Ribble Valley Borough Council  
Council Offices  
Church Walk,  
Clitheroe  
Lancashire  
BB7 2RA

Phone: 0300 123 6780  
Email: [developeras@lancashire.gov.uk](mailto:developeras@lancashire.gov.uk)  
Your ref: 3/2025/0357  
Our ref: 3/2025/0357/HDC/KW  
Date: 09 June 2025

**Location:** Horrocksford Old Hall Farm West Bradford Road Clitheroe BB7 4QD  
**Proposal:** Proposed change of use from farm dwelling to offices for Ribble River Trust.  
**Grid Ref:** 374848 443907

Lancashire County Council acting as the Local Highway Authority (LHA) does not consider that the application as submitted fully assesses the highway impact of the proposed development and further information is required as set out in this response.

Client RIBBLE RIVERS TRUST	Scale NOTED Date JUNE 25 Drawn WS	Drawing title ACCESS DETAILS
Job title ALTERATIONS HORROCKSFORD FARM HOUSE	<b>1200 D026</b>

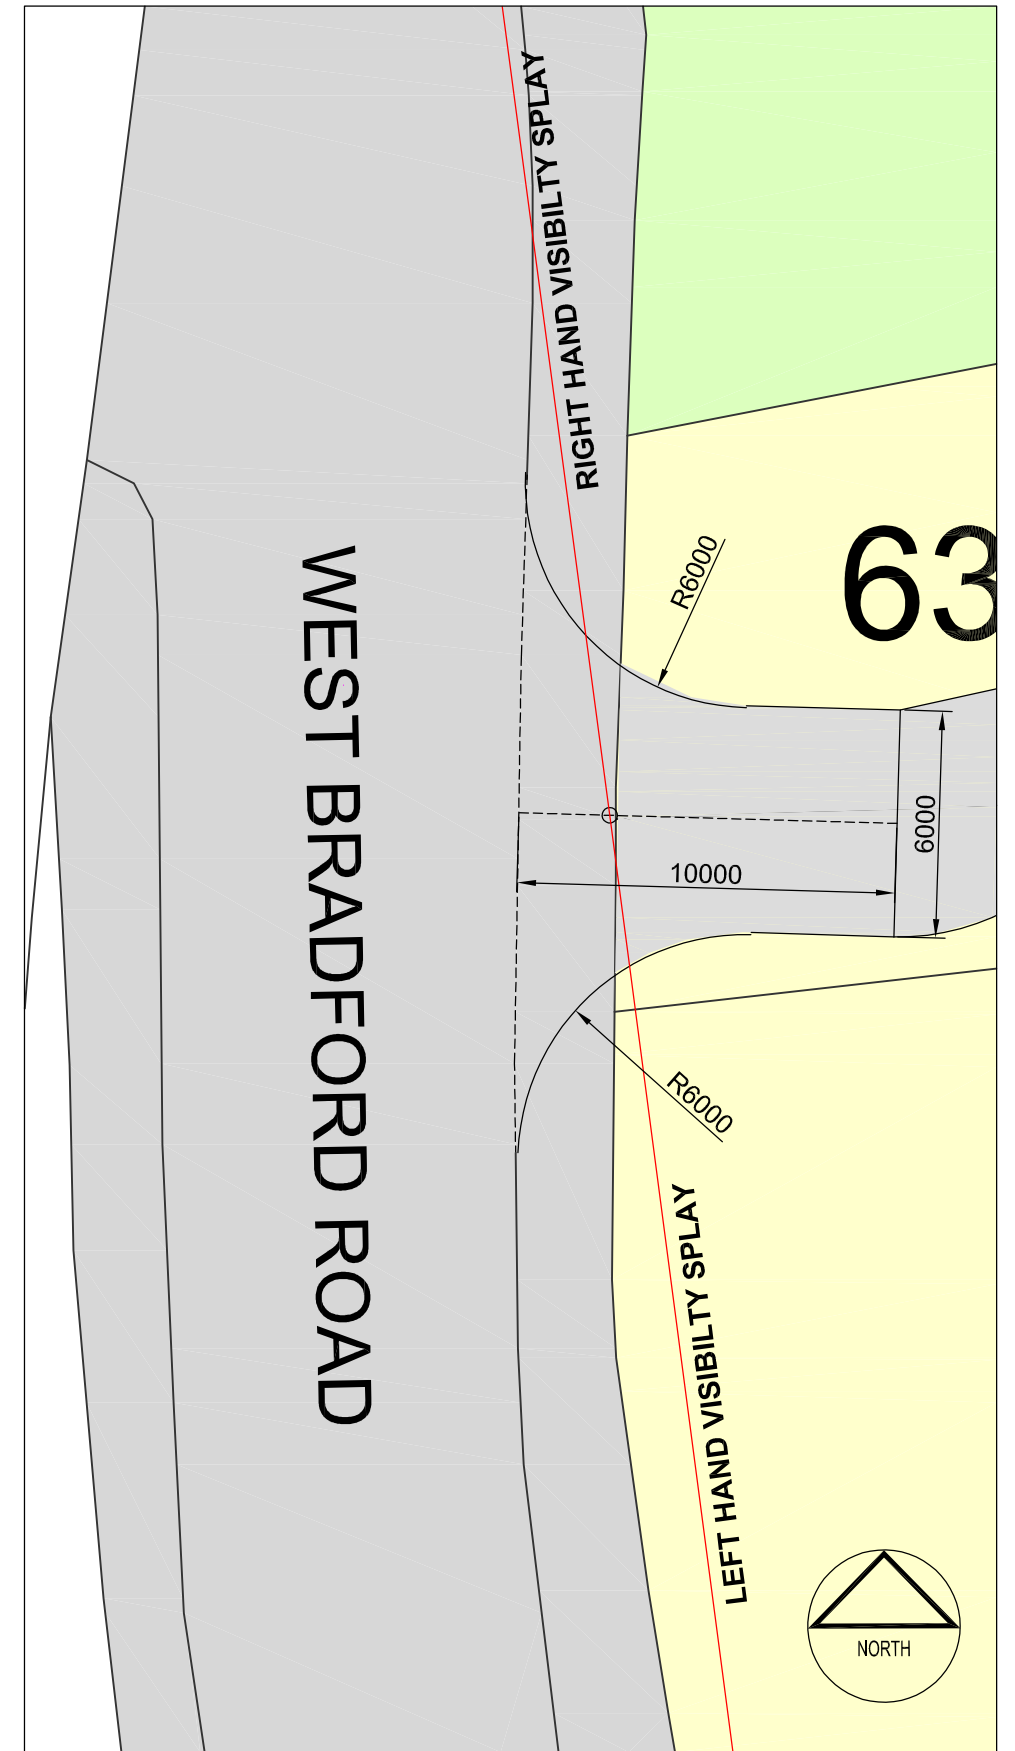
However, a detailed access plan should be submitted as part of the application, showing the widths of the access and access road so the LHA can review if the access is an acceptable width to support the intensification of its use following the development.

A swept path analysis for a twin axel refuse vehicle should be provided or a 6m wide access for a minimum of 10m into the site supported by a 6m radius should be provided to support ingress and egress of either a larger vehicle that would be expected at the site such as a refuse collection vehicle or for allowing two way movement of vehicles.

An internal access road is proposed between the site access and the car parking provisions, which was initially considered as part of application 3/2015/0954 to support agricultural access to the site. Given the intensification of the proposal and change of use the LHA would require a detailed plan showing the full width of the internal access road, the internal access road should support two way movement as such it should be at least 5.5m wide for its entire length.

The site would also benefit from pedestrian facilities in line with inclusive mobility guidance which may reduce the reliance on private vehicles as such the site would benefit from 2m wide footway provisions from the access into the site.

In conclusion, while the existing access from West Bradford Road has been previously approved, further detailed assessments are required to ensure its suitability for intensified use, including swept path analysis and/or width measurements to support safe vehicle movements.
